From: Simon Power
Sent: 01 July 2010 12:46
To: Planning.Responses
Cc: Jonathan Parsons; Brian Holland
Subject: RE: Planning Consultation on: AL/27/09/DOC at The Homestead

[Application to discharge condition Nos 9 & 10 of AL/23/06.](#)

APPLICATION NO: AL/27/09/DOC

Registered: 23-APR-09
Site Address: The Homestead Westergate Street Westergate

TYPICAL AQUACELL INSTALLATION (INFILTRATION METHOD)
(Scale 1:20)

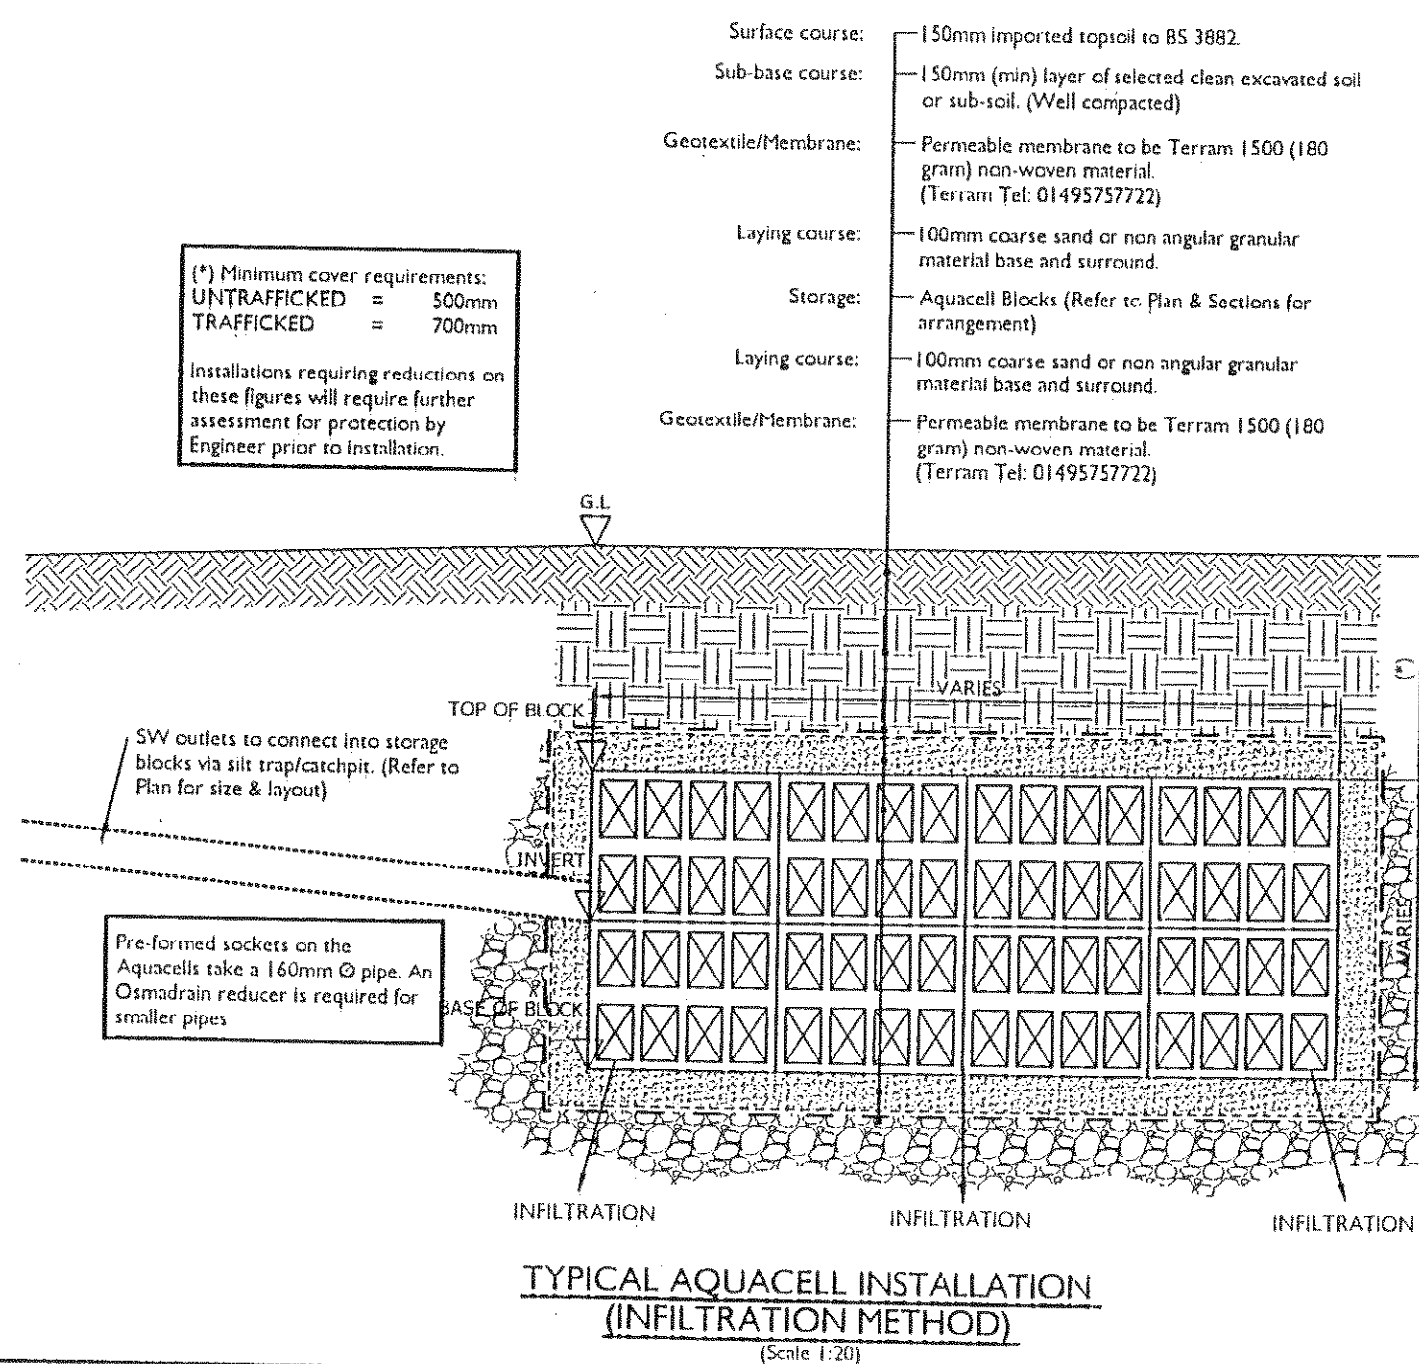
7. Provide calculations showing that the half emptying time of each of the soakaways is achieved within 24 hours, ready for a following storm event.
8. Confirm that "Aquacell" storage units as specified on drawing No 6902(A1)110 Rev P2 will be used to achieve the 95% void ratio. Opus calculation sheets are headed "Reject/Rubble filled soakaway". A 95% void ratio will not be achieved with reject material, and rubble is totally unacceptable.
